Our Ref: FP/237/19/HH

Town & Country Planning Act 1990 (as amended)
Town & Country Planning (Development Management Procedure) (England) Order 2015
Application for Planning Permission for Works or Extension to a Dwelling

Development Single storey entrance porch with new partial pitched roof to existing rear extension and garden terrace area

Location 1 Davenport Road Felpham

Site Block Plan

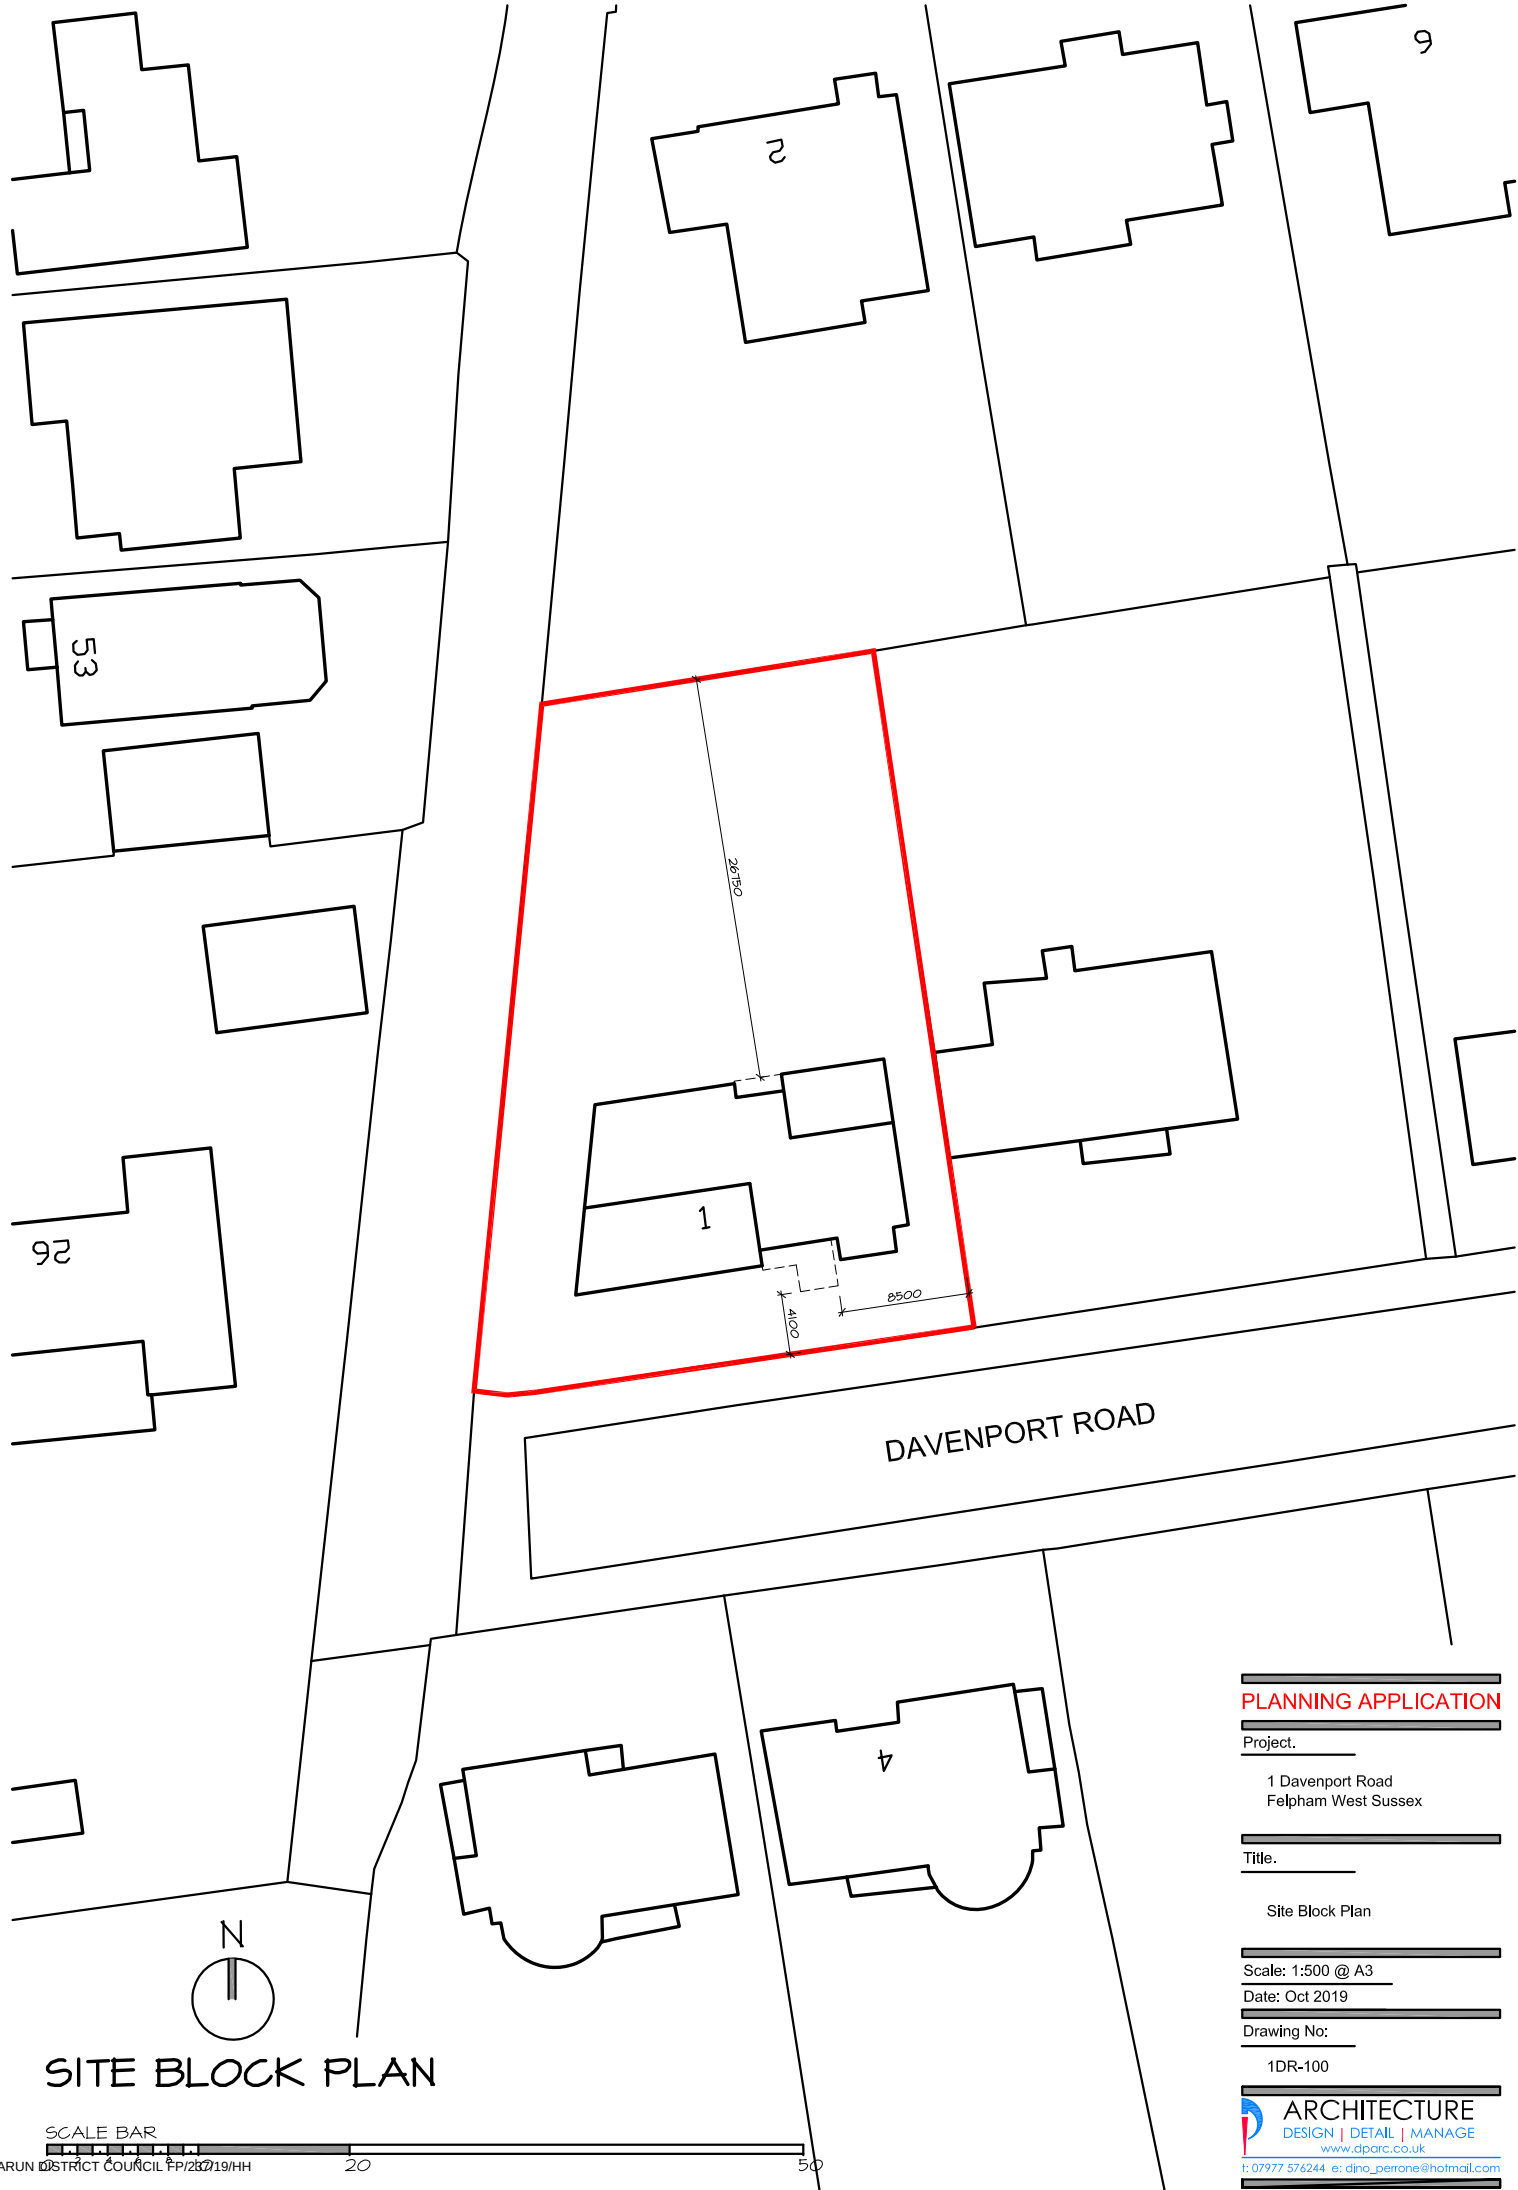
Please submit a block plan which includes dimensions from the proposed extension to all site boundaries.
